**CITY OF ALBUQUERQUE
PLANNING DEPARTMENT
April 30, 2014
DRB Comments**

ITEM # 11

PROJECT # 1010053

RE: Lot 3-A, Block 1, Vidas Subdivision

**SITE PLAN FOR
LOT 3-A, BLOCK 1
VIDAS SUBDIVISION**

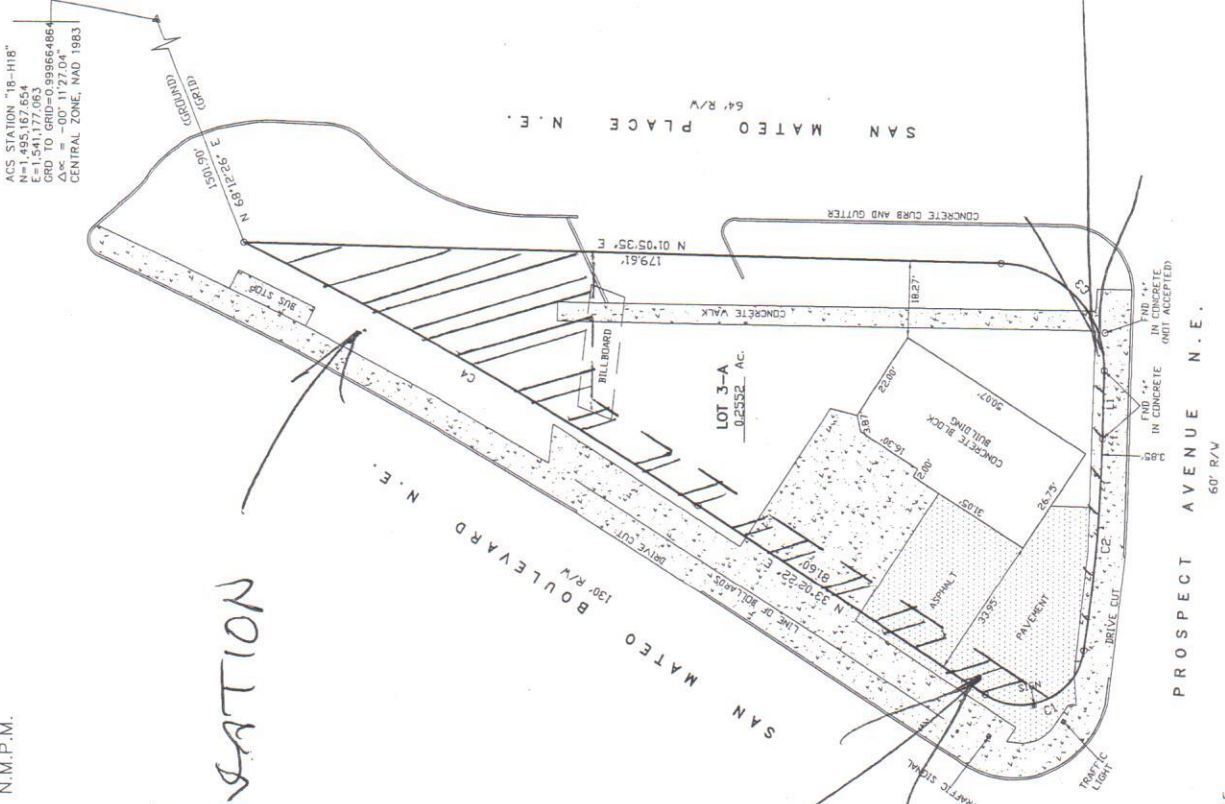
The standard street cross-section needs to allow for a sidewalk within the San Mateo Blvd right of way. This may allow for up to 10 feet of right of way to be vacated if a Design Variance is requested and approved for the standard distance from back of curb to property line for an arterial street – refer to comments from Transportation Development.

If the vacation is approved the right of way would have to be acquired from the City and replatted into the site parcel – with the replat it appears the southernmost drive pad closest to the intersection of Prospect may need to be replaced with standard sidewalk, curb and gutter. It appears a request for a Sidewalk Waiver on San Mateo Place would be needed with the replat – again, refer to comments from Transportation Development.
